Re: CHUZE Albuquerque
6600 Central Ave, SW
Albuquerque, NM 87121

Project Number: 21-6039-01
Permit Number: 2022-006777

Subject: Plan Check Correction List – Round 2

SITE PLAN

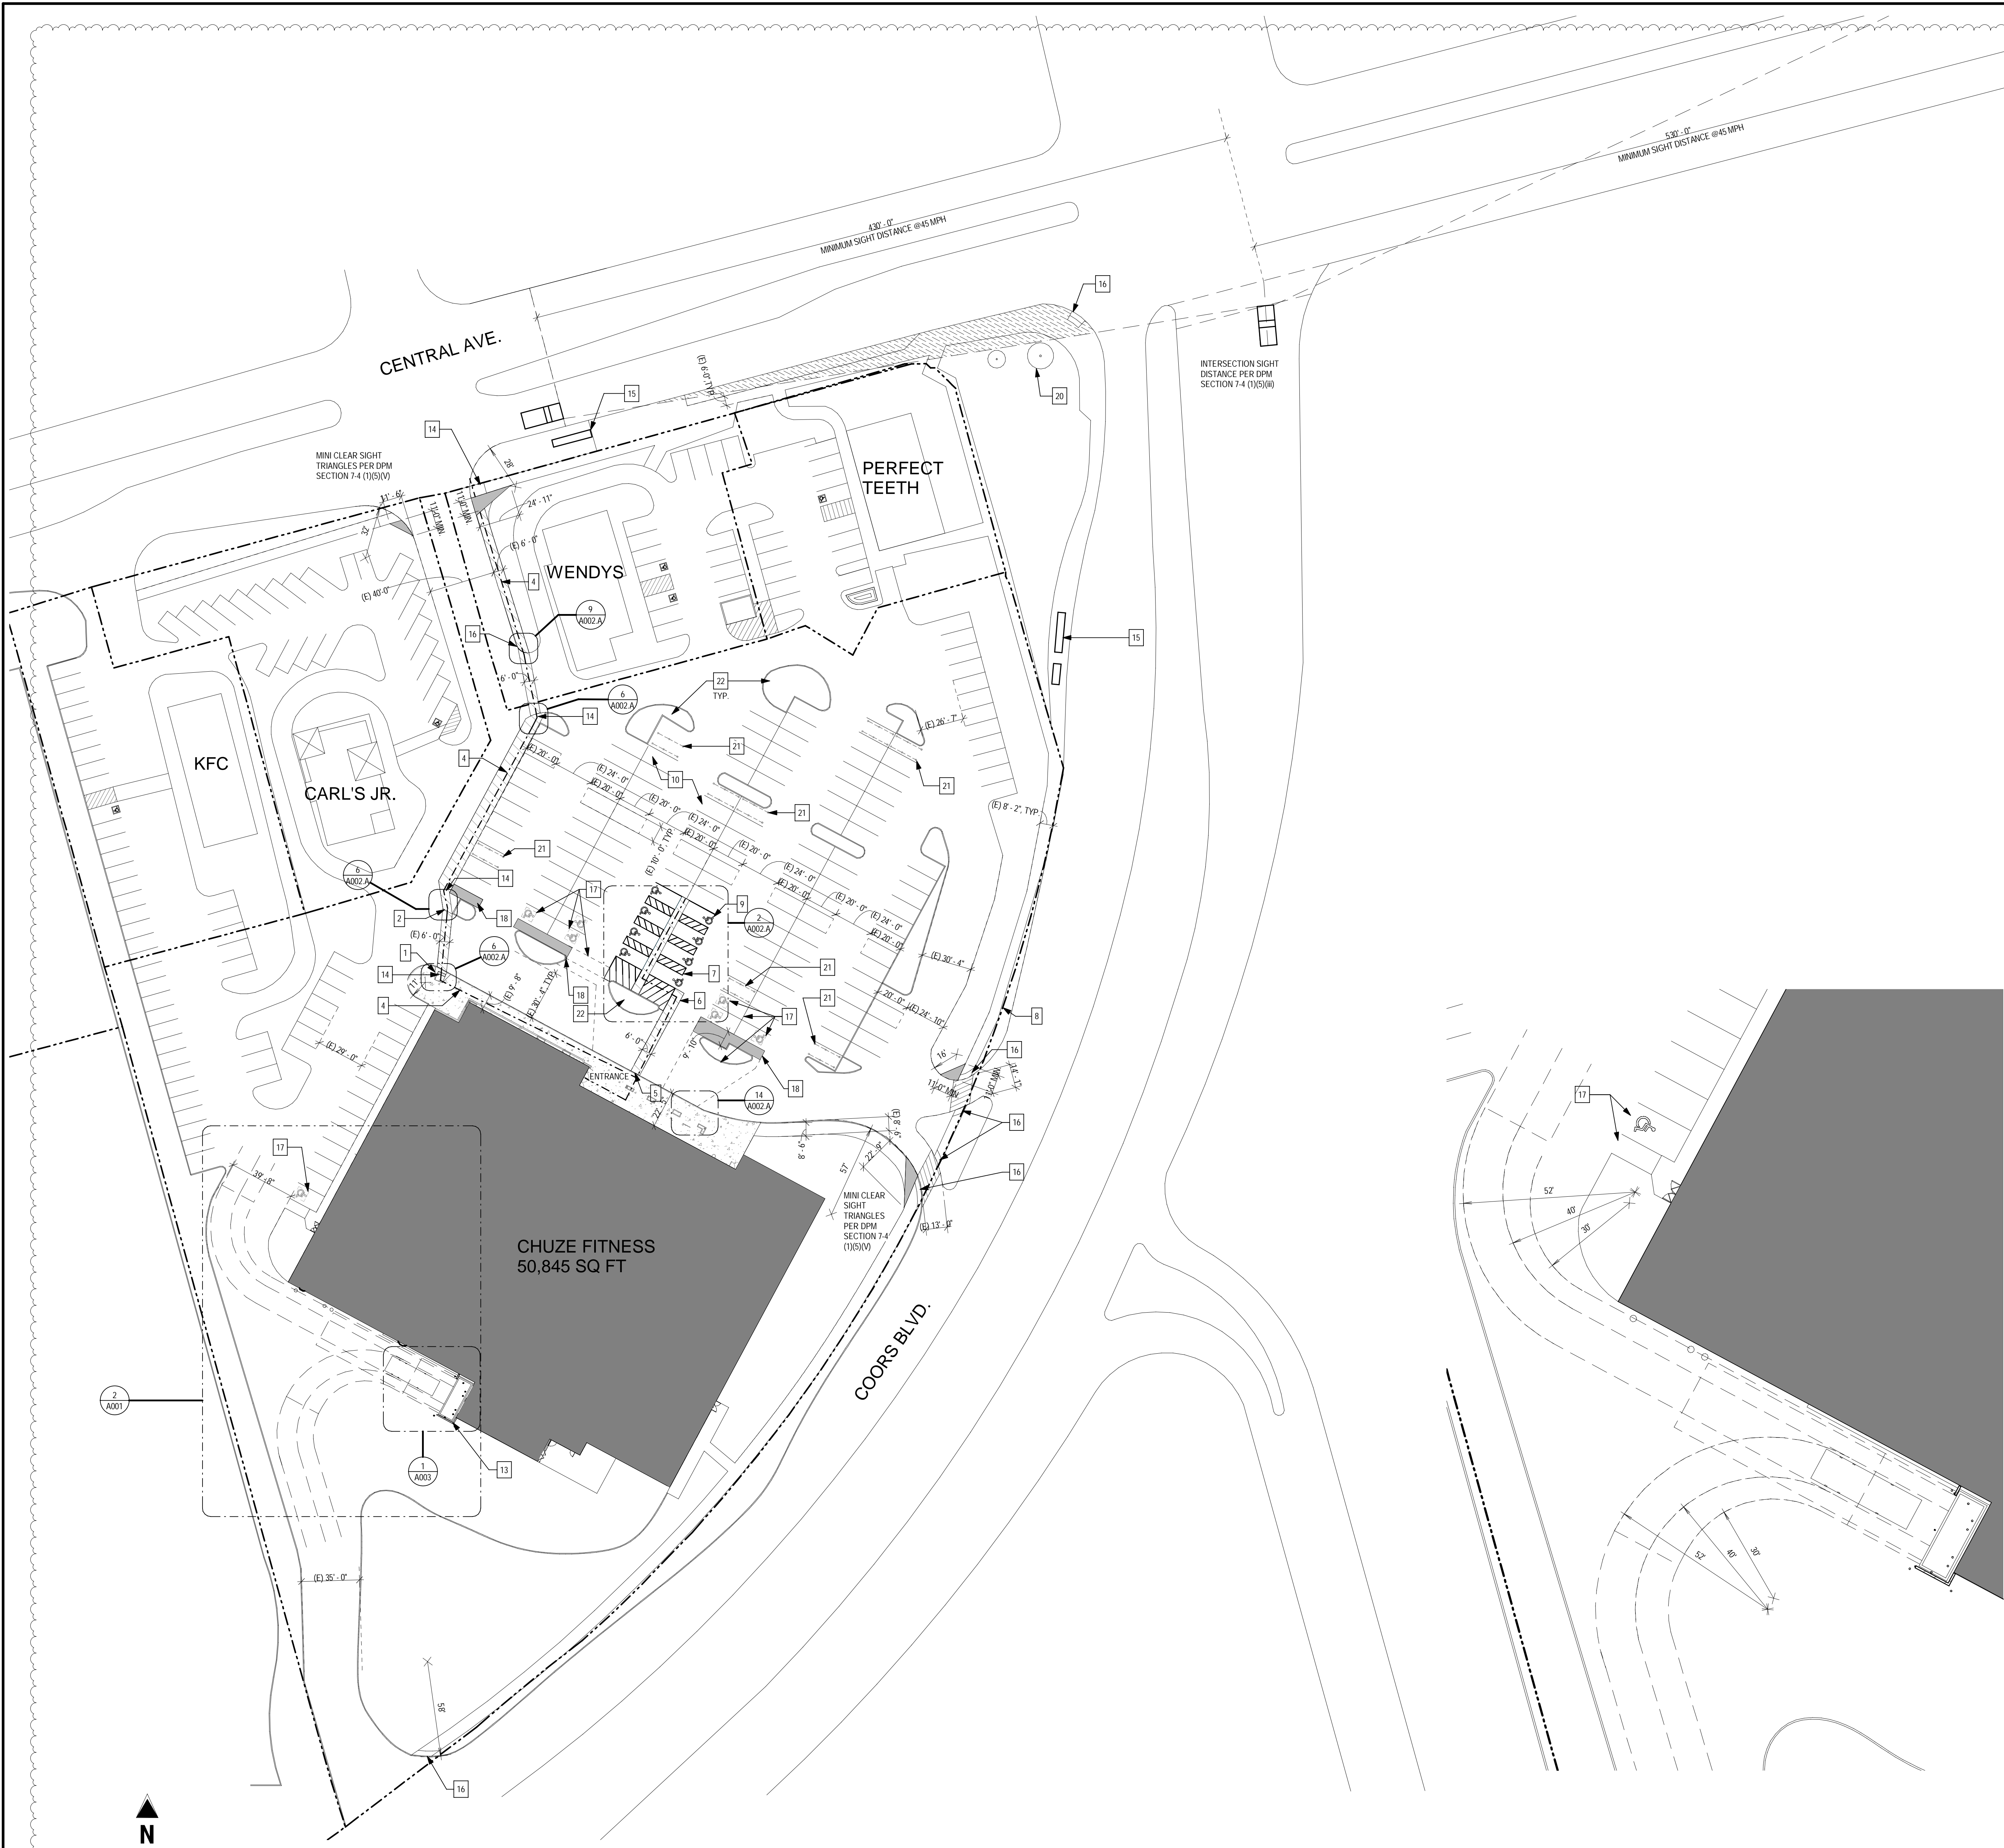
1. List the number of parking spaces required by the IDO as well as the proposed number of parking spaces including bicycle and motorcycle parking.
Response: 2.5 Spaces / 1,000 S.F. per GFA. IDO section 5-5 (C)(2) has been provided on sheet A001.
2. Provide shared parking agreement.
Response: Parking agreement between owner and tenant is provided on attached documents as part of the Executed lease documents.
3. Provide the dimension for all existing parking spaces, existing sidewalk, existing driveway entrance, and existing drive aisles.
Response: Dimensions for existing parking spaces, sidewalk, driveway entrance and drive aisles have been provided on sheet A001.
4. The minimum parking stall dimensions are:
Response: All existing parking space dimensions have been provided on Site Plan sheet A001.

14. List radii for all curves shown; for passenger vehicles. Radius for delivery trucks, fire trucks, etc. is 25 ft. or larger.
Response: Radii for passenger, delivery trucks and fire has been included in site plan sheet A001 and detail 2/A001.

15. Per the IDO, a 6 ft. wide ADA accessible pedestrian pathway is required from the public sidewalk to the building entrances. Please clearly show this pathway and provide details.

Response: Existing 6'-0" wide ADA accessible pedestrian pathway from Central Ave. to remain, see site plan sheet A001.
16. Per DPM, a 6 ft. wide ADA accessible pedestrian pathway is required from the ADA parking stall access aisles to the building entrances. Please clearly show this pathway and provide details.

19. Curbing should be installed to delineate landscape, parking, and pedestrian ways and identify points of access. Please call out detail and location of barrier curb.

23. Show the Intersection Sight Distance (for Coors Blvd. SW) and add the following note to the plan: "Landscaping and signage will not interfere with clear sight requirements. Therefore, signs, walls, trees, and shrubbery between 3 and 8 feet tall (as measured from the gutter pan) will not be acceptable in the clear sight triangle.

25. Add a note stating "All broken or cracked sidewalk must be replaced with sidewalk and curb & gutter." A build note must be provided referring to the appropriate City Standard drawing.

Response: Existing 6'-0" wide ADA accessible pathway from Central Ave. to remain, see sheet A001.
18. Please show on-site plan the entrance doors.
Response: Entrance doors have been indicated on the site plan sheet.

21. Provide a copy of Fire Marshal Approval.
Response: To be provided by Albuquerque Fire Rescue.
22. Please provide a sight distance exhibit.
Response: Intersection Site Distance and Mini Site Triangles have been provided, see sheet A001.

Response: A note "Landscaping and signage will not interfere with clear sight requirements. Therefore, signs, walls, trees, and shrubbery between 3 and 8 feet tall (as measured from the gutter pan) will not be acceptable in the clear sight triangle" has been added to sheet A001.

Response: A note, "All broken or cracked sidewalk must be replaced with sidewalk and curb & gutter" has been added to sheet A001, referencing city standard drawing 2415C.

4 ADA ACCESSIBLE PARKING SIGN
SCALE: 1/2" = 1'-0"

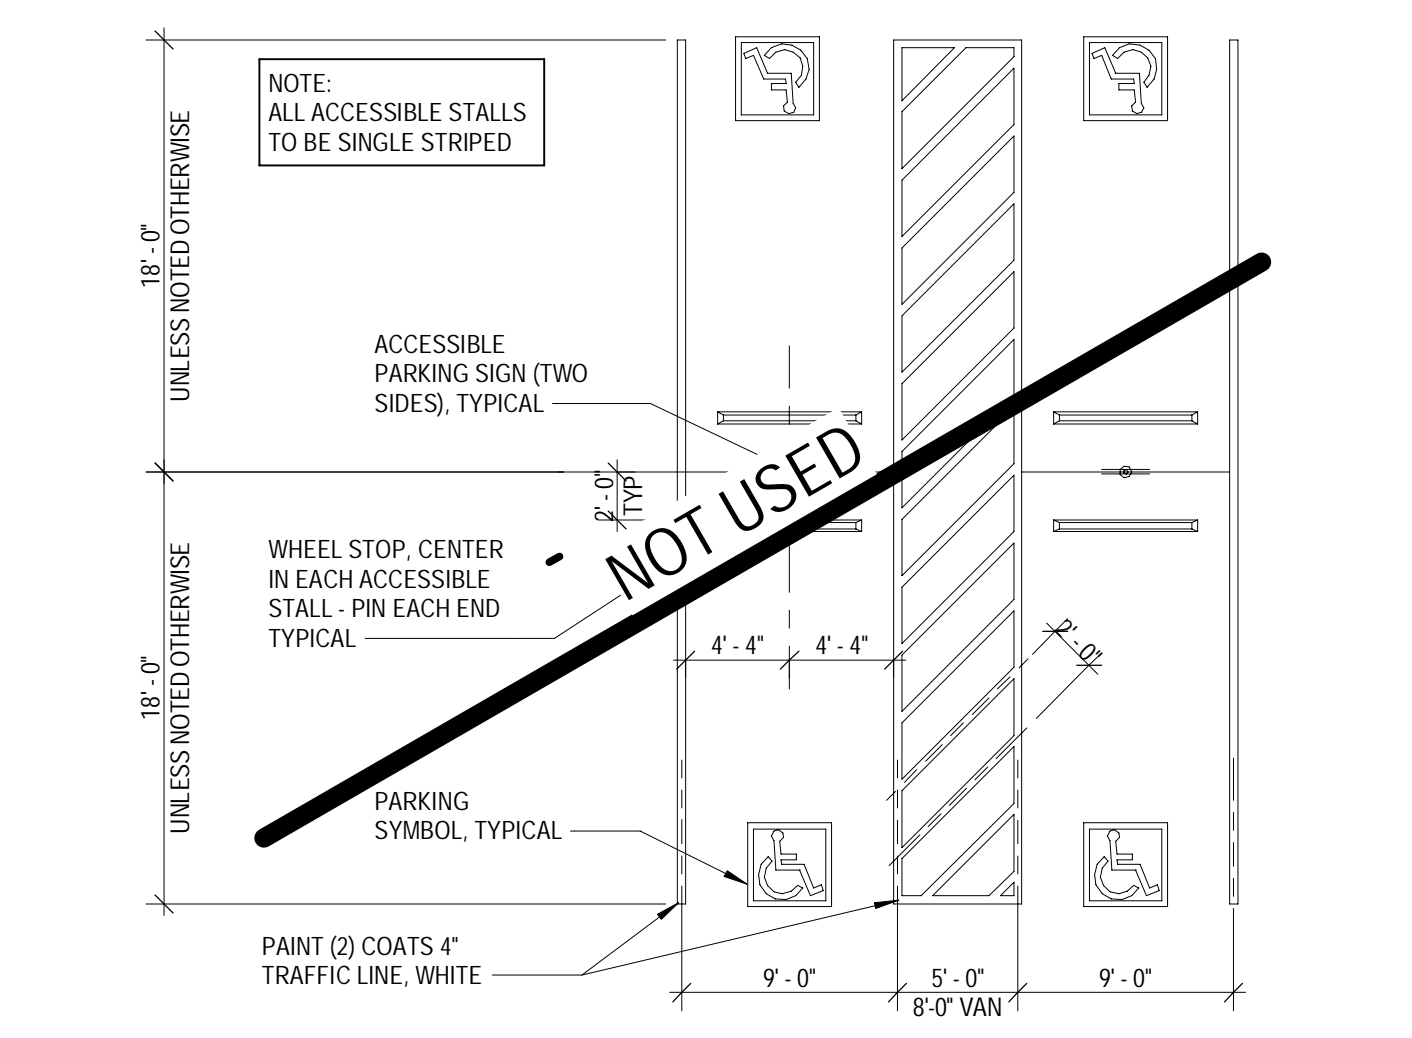
6. The ADA accessible parking sign must have the required language per 66-7-352.4C NMSA 1978 "Violators Are Subject to a Fine and/or Towing." Please call out detail and location of signs.

Response: A Note "Violators Are Subject to a Fine and/or Towing" has been added to detail 7 on sheet A002.A.
7. The ADA access aisles shall have the words "NO PARKING" in capital letters, each of which shall be at least one foot high and at least two inches wide, placed at the rear of the parking space so as to be close to where an adjacent vehicle's rear tire would be placed. (66-1-4.1.B NMSA 1978)

2 ACCESSIBLE PARKING STALLS WITH WALK
SCALE: 1/8" = 1'-0"

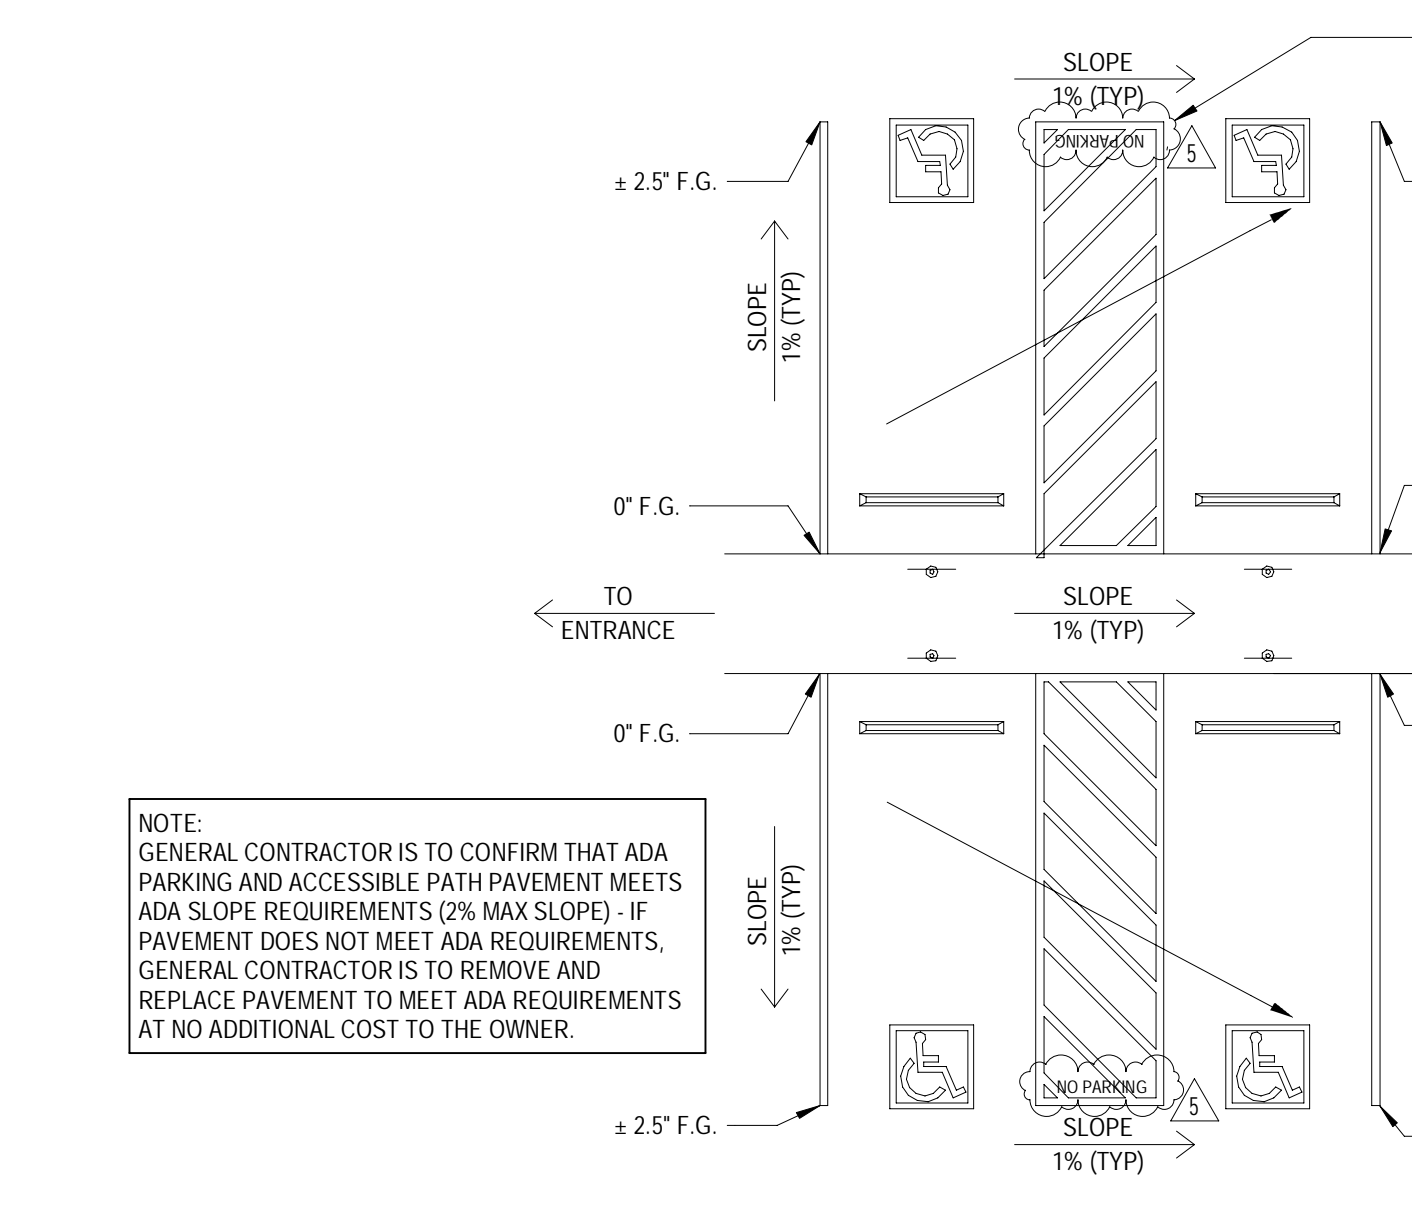
5. The ADA accessible spaces must include an access aisle. Van accessible aisles should be 8ft wide; all others should be 5ft wide.
Response: 8 foot and 5 foot accessible spaces have been provided, see sheets details 1 & 2 on sheet A002.A.

Response: "NO PARKING" letters have been provided, see details 1 & 2 on sheet A002.A.
8. ADA curb ramps must be updated to current standards and have truncated domes installed.

14 ENLARGED BIKE FLOOR PLAN
SCALE: 1/4" = 1'-0"

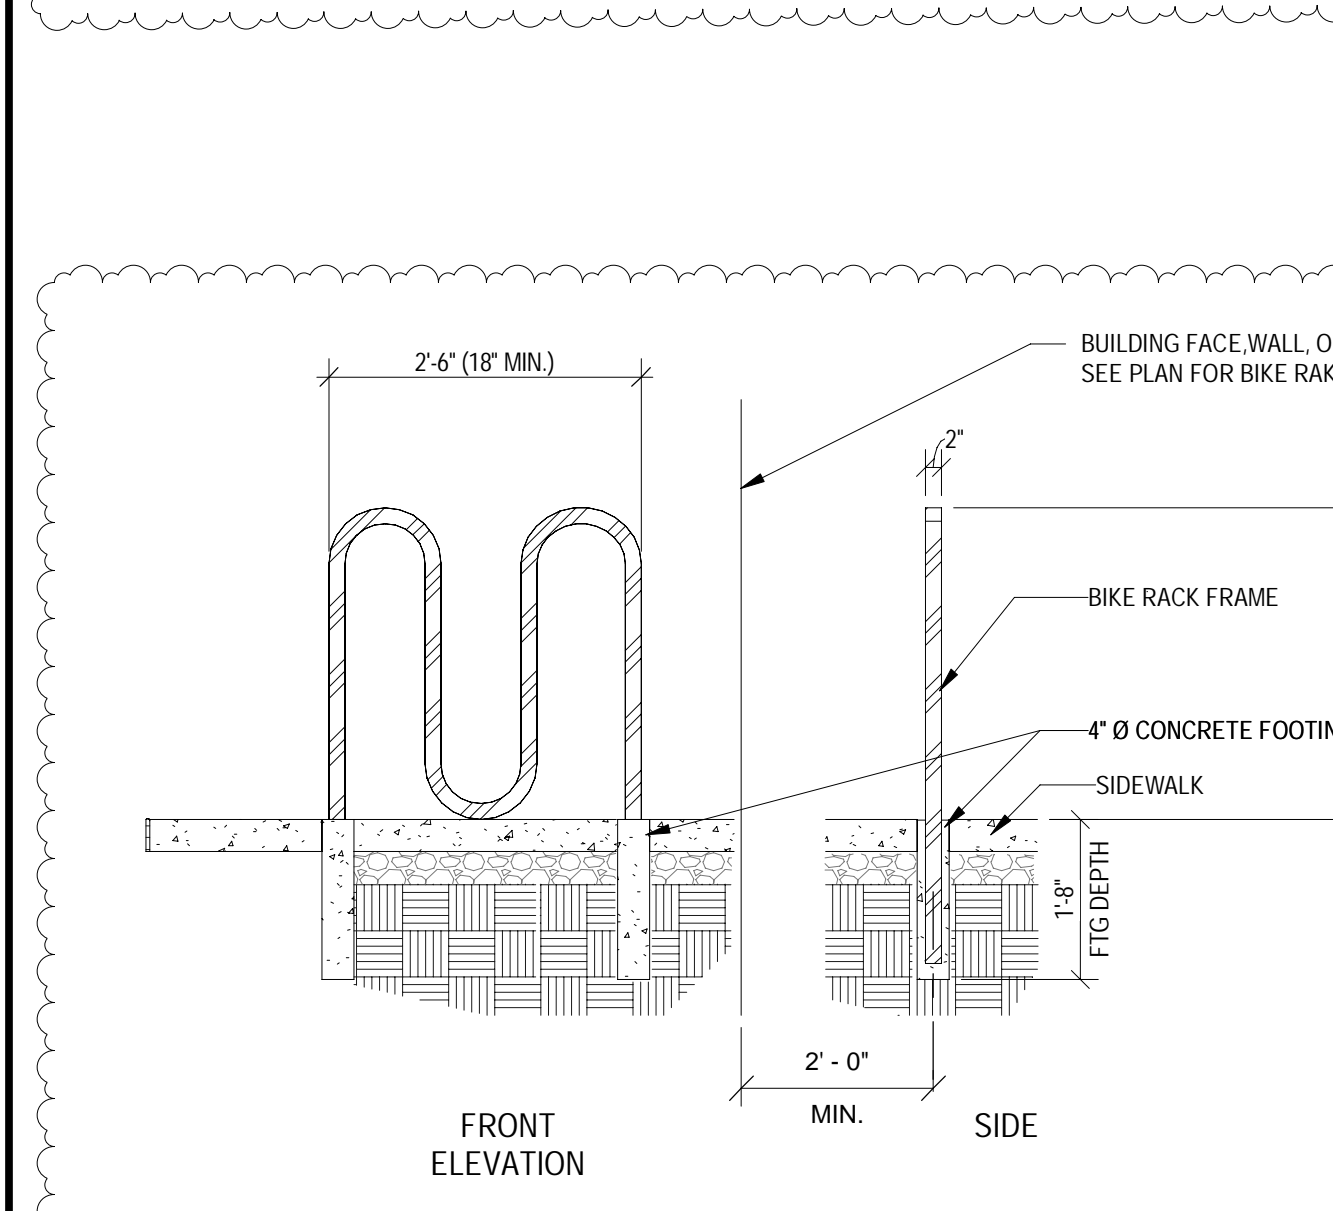
- f. Each bicycle parking space is accessible without moving another bicycle.
Response: See detail 13 & 14/A002.A.
11. Bicycle racks shall be sturdy and anchored to a concrete pad.

Response: See detail 13 & 14/A002.A.
12. A 1-foot clear zone around the bicycle parking stall shall be provided.
Response: A 1-ft clear zone around bicycle parking stall has been provided, see detail 14/A002.A.

13. Bicycle parking spaces shall be at least 6 feet long and 2 feet wide.
Response: A 6 foot and 2 foot wide bicycle parking space has been indicated, see detail 14/A002.A.

- d. The rack allows varying bicycle frame sizes and styles to be attached.
Response: See detail 13 & 14/A002.A.
 - e. The user is not required to lift the bicycle onto the bicycle rack.

Response: See detail 13 & 14/A002.A.
